**Our ref:** LT/2020/125045/01-L01  
**Your ref:** A38 NSIP  
**Date:** 21 February 2020

**ISSUE SPECIFIC HEARING 3 AND 4 ON THE 18TH AND 19TH FEBRUARY 2020 - ENVIRONMENT AGENCY RESPONSE A38 DERBY JUNCTIONS**

Drawing Title  
FIGURE 2.6  
MARKEATON JUNCTION  
GENERAL ARRANGEMENT

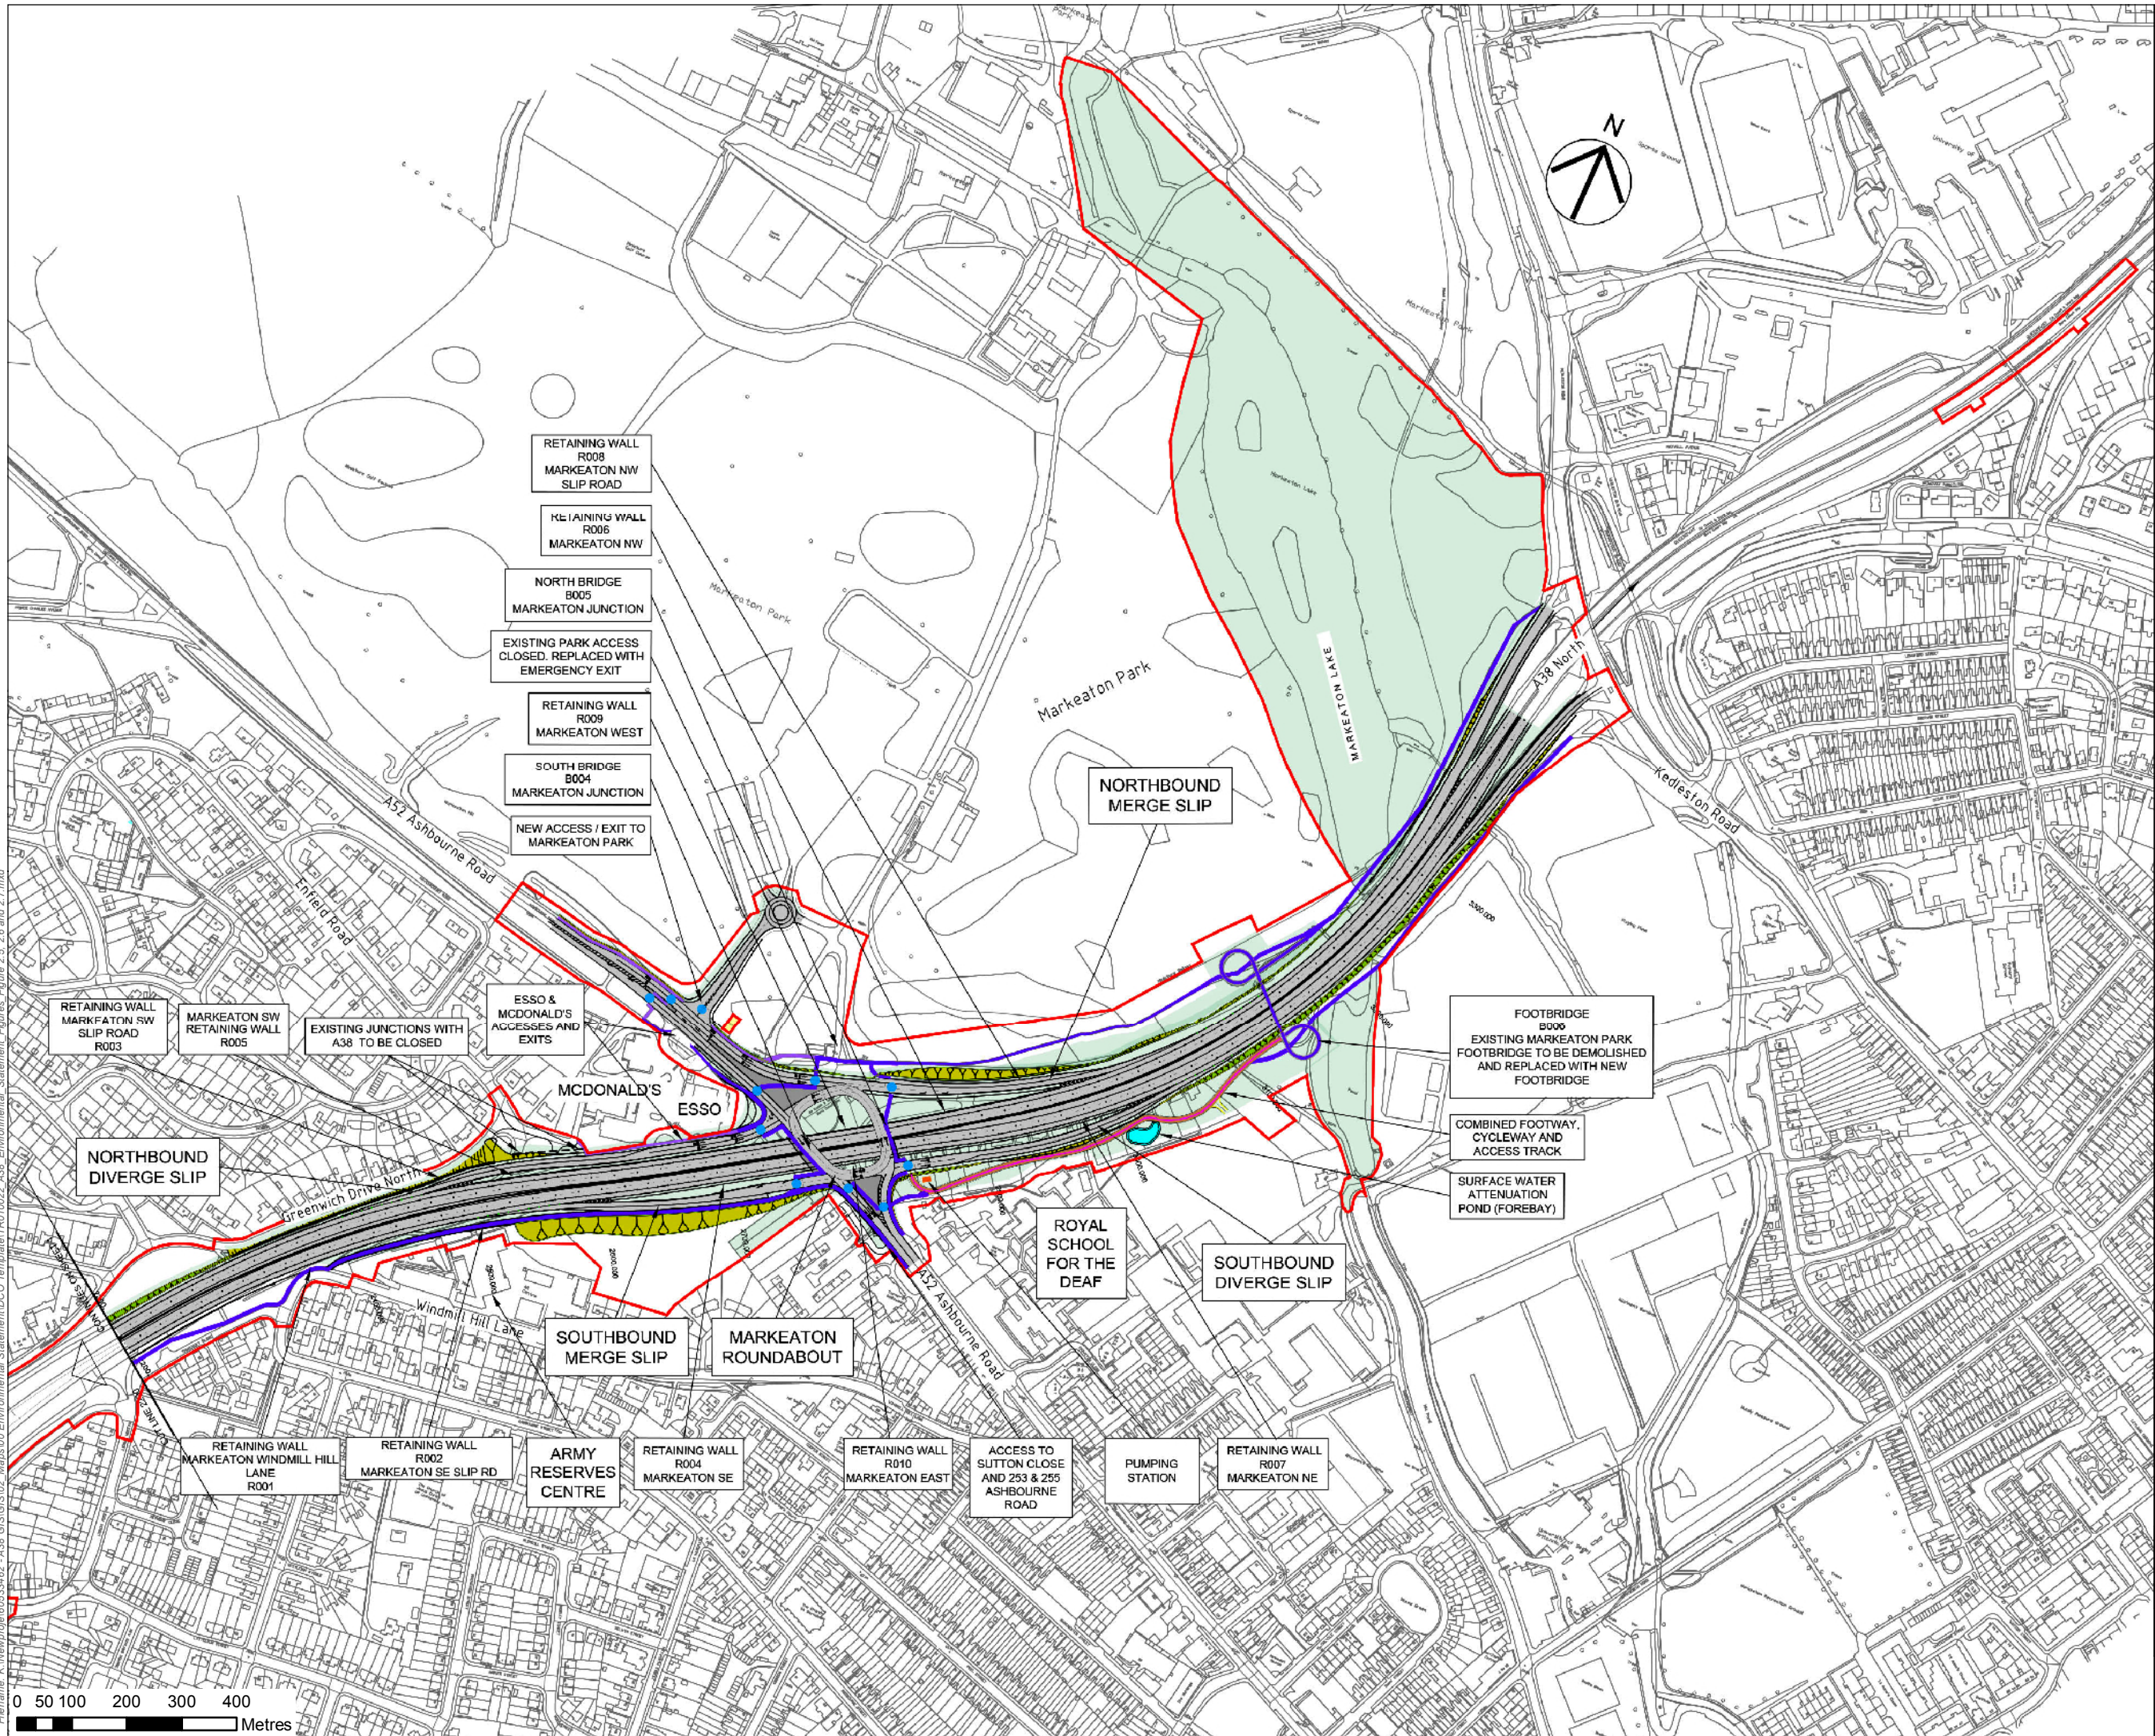
**Markeaton Brook Modelling** – We can confirm that the latest model the Environment Agency has for the Markeaton Brook is our Derby City Tributary model that was undertaken in 2013.

Drawing Title  
FIGURE 2.7  
LITTLE EATON JUNCTION  
GENERAL ARRANGEMENT

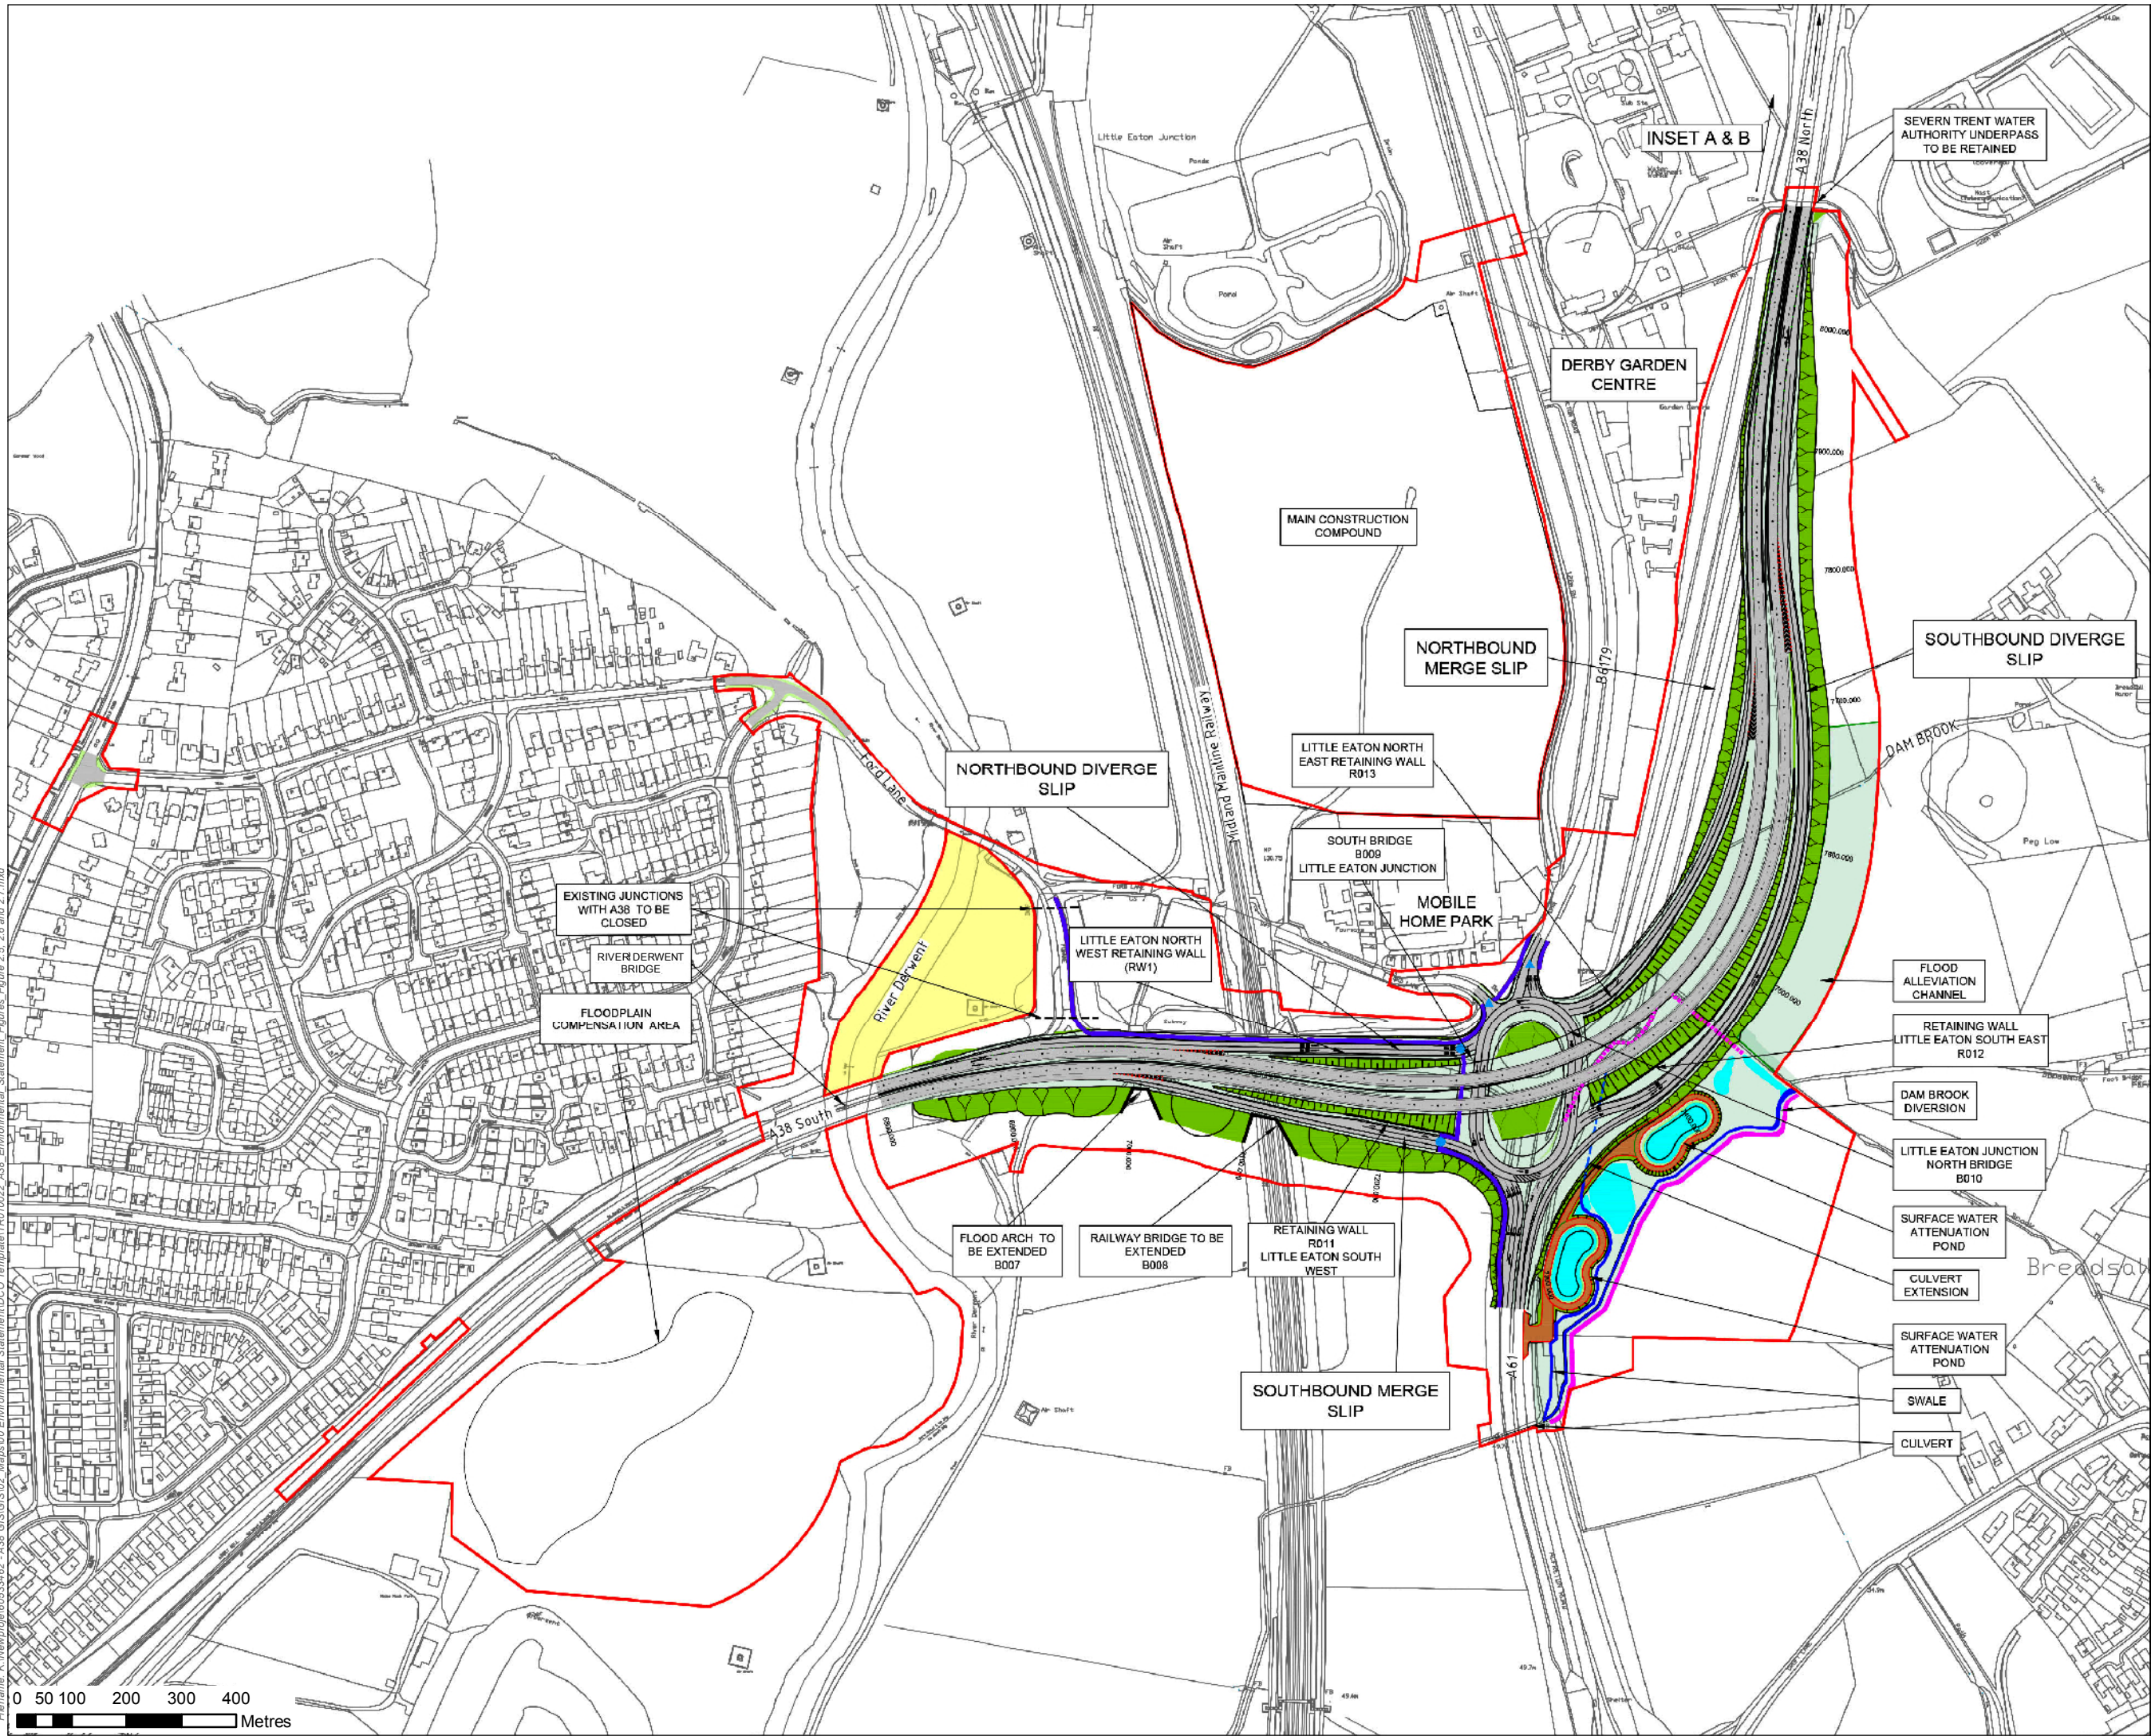
**Climate Change Allowances** – As previously mentioned in our response to the written questions. The Environment Agency are satisfied with the 50% allowances proposed for the Little Eaton junction. Climate change allowances requirements are detailed on gov.uk dependent on the vulnerability of the development and the flood zone the development is situated in. For essential infrastructure in FZ3 the upper end climate change allowance in the Humber catchment would need to be used which is a 50% allowance, which is being proposed for the Little Eaton junction.
